PROJECT: Land adjacent Woodgate Nurseries, Lidsey Road, Woodgate

PLANNING REFERENCE: AL/129/21/OUT

REPORT: 2087/TN/04 – Response to highway officer comments dated 30th November 2021

DATE: December 2021

Figure 4.2 – Proposed site access junction

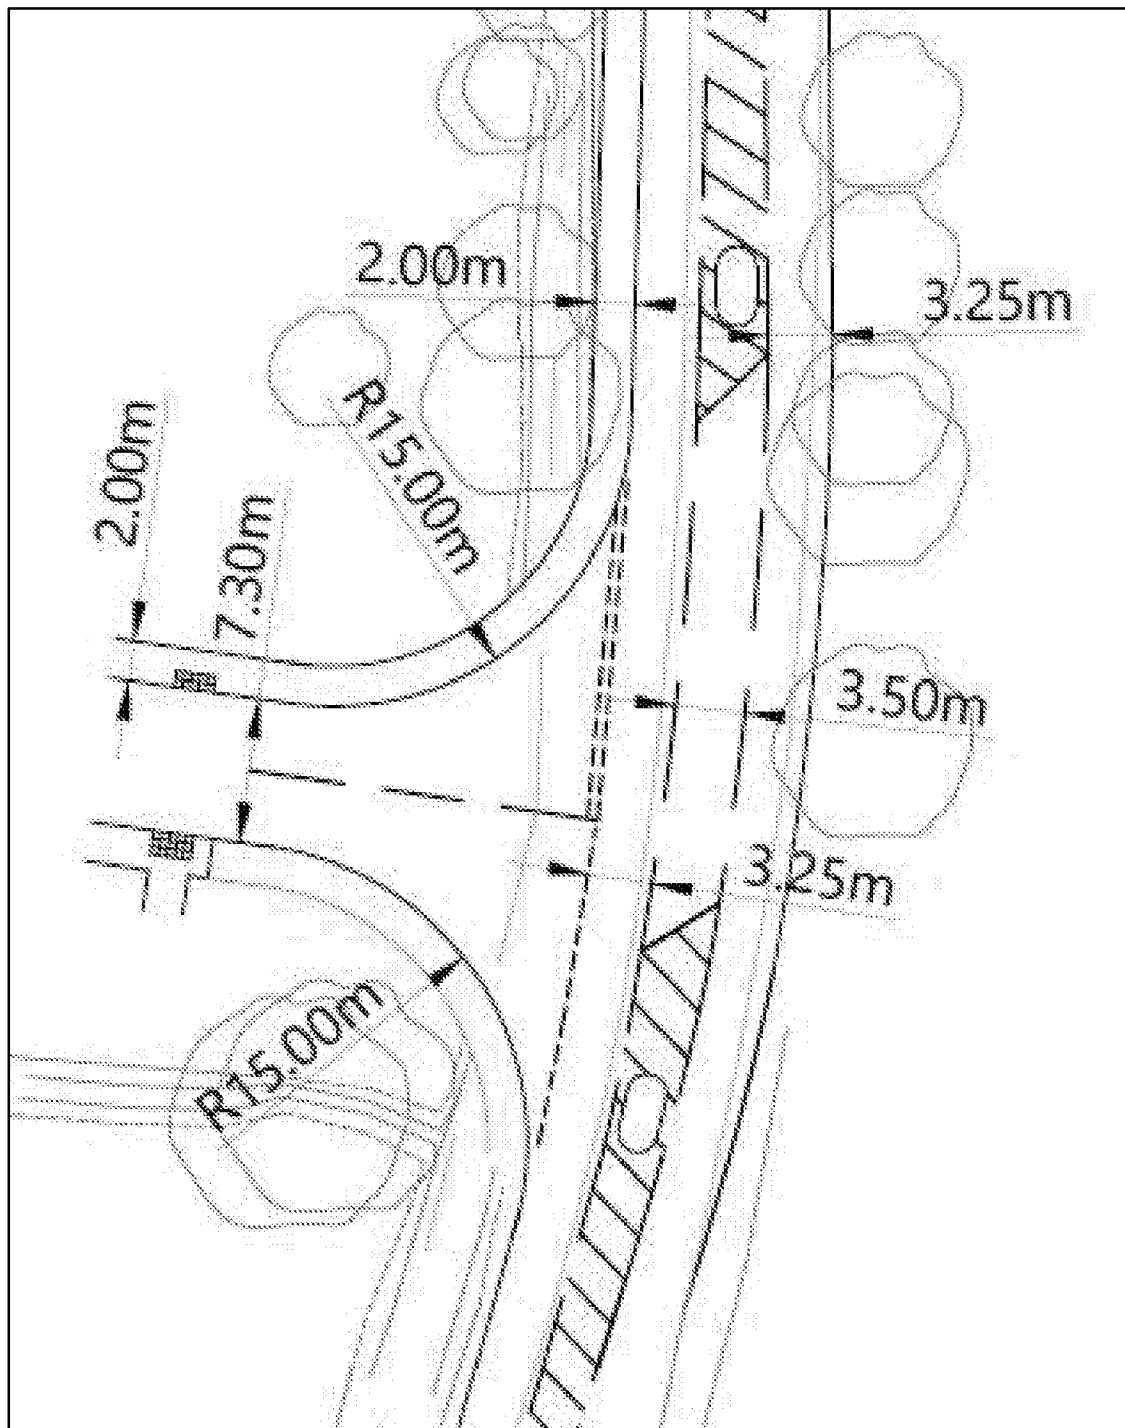
- iv. Agreement that the details of temporary and/or permanent warning signage can be determined as part of the S278 process.
 - v. The proposed site access plan should be modified to include:

- The path in north eastern corner of the site should be widened to allow for cycle access in addition to pedestrian access.
 - The footway along Lidsey Road to the north of the site should be widened to 2.0 metres up to where it meets the highway improvements associated with the Wing's Nursery development (AL/32/19/OUT).

- vii. A formal design check on the access junction should be undertaken and submitted along with any associated relaxation/departure forms.

Recommendation 3 – Reallocate road space or widen traffic island to ensure widths between 3.2m or 3.5m are avoided.

4. In respect of **paragraph 3.v.**, the proposed site access plan has been modified slightly as a result of the design check requested in the consultation response and this is shown on drawing HTp/2087/36 (provided at **Appendix 2**). The modifications comprise:

- i. The path between the north eastern corner of the site and Lidsey Road has been widened to 3.0 metres to allow for access by cyclists in addition to pedestrians.

- ii. This modified path is complimented by a dropped kerb to allow access to and from Lidsey Road with ladder paving to warn pedestrians walking along Lidsey Road that cyclists may be crossing.

- iii. The footway along Lidsey Road to the north of the site being widened to 2.0 metres to the southern extents of the highway works area associated with the Wing's Nursery development.

- v. At the site access junction, minor modifications to the southern kerb line of the site access, the location of traffic islands and road markings.

9. During the design check the following changes to the access were made:
 - i. The direct taper was increased from 5 metres to 15 metres.
 - ii. The traffic islands were relocated to better accommodate the CD123 design vehicle, even though movements by 16.5 metre articulated vehicles are expected to be exceptionally rare.
